DRB Application No.: <u>07DRB-00269 (P&F)</u>	Project # <u>1005412</u>
Project Name: <u>LANDS OF AKIN</u>	
Agent: <u>Surveys Southwest</u>	Phone No.: <u>998-0303</u>

**DEVELOPMENT REVIEW BOARD
TRANSPORTATION DEVELOPMENT
Standard Comment Sheet**

DRB- 1005412 Item No. 12 Zone Atlas H-13

PLAT OF
 TRACTS A & B
 LANDS OF AKIN
 PROJECTED SECTION 7, T. 10 N., R. 3 E., N.M.P.M.
 TOWN OF ALBUQUERQUE GRANT
 CITY OF ALBUQUERQUE
 BERNALILLO COUNTY, NEW MEXICO
 MARCH 2007
 SHEET 2 OF 2

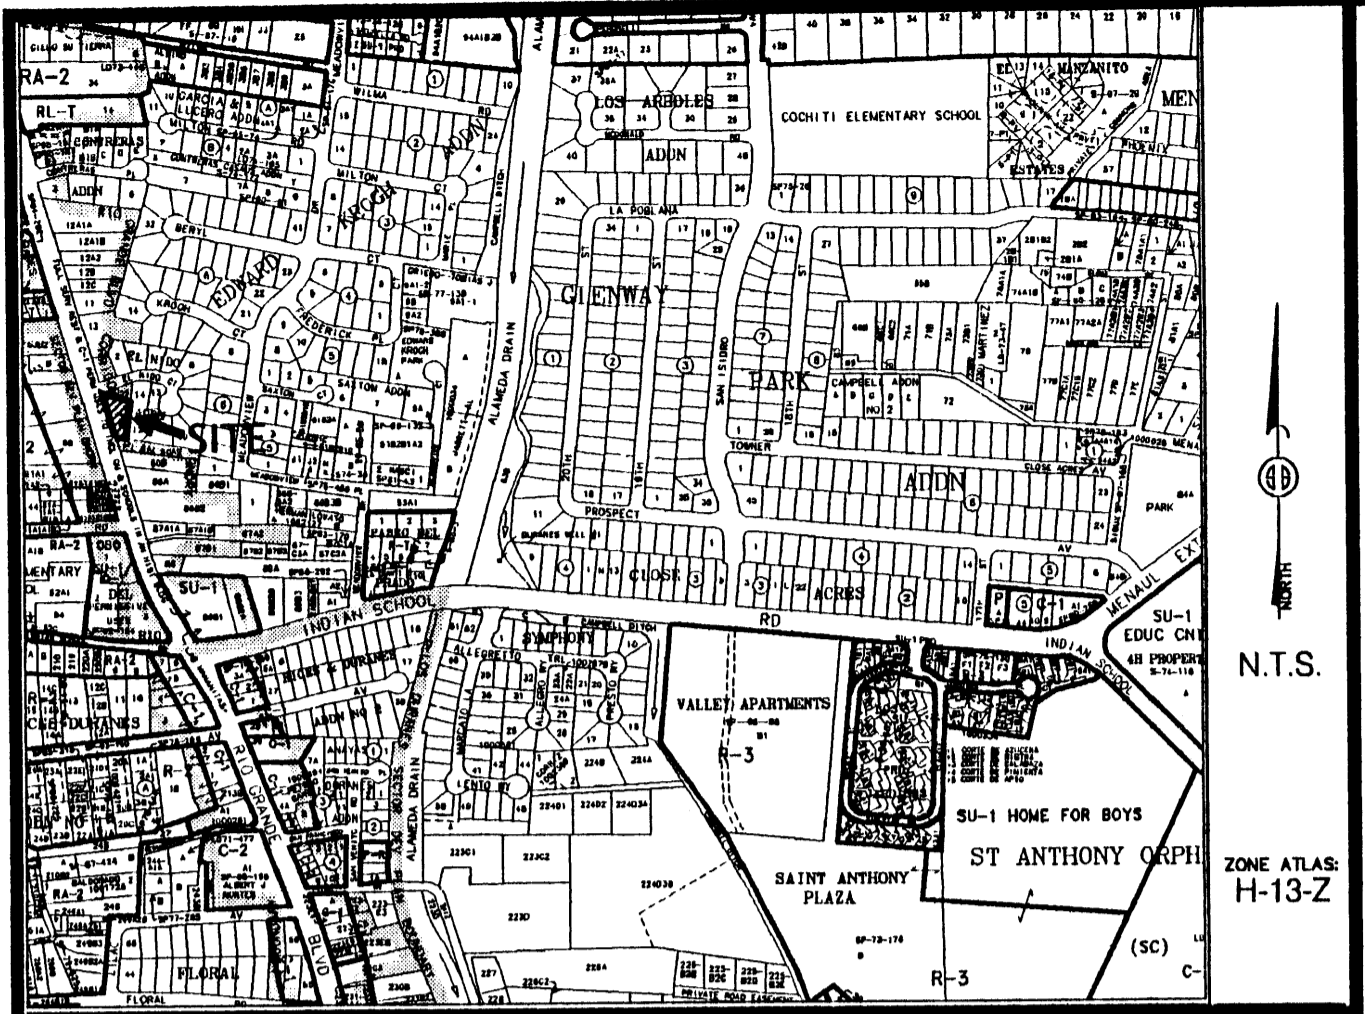
- TRANSPORTATION: access easement to Tract A
 3' PUBLIC ROADWAY EASEMENT ALONG RIO GRANDE

- 1) Tract A does not have access. Isn't this tract supposed to extend south and provide x-access with Tract B?
- 2) Where are the 3' public roadway easements around the existing buildings?
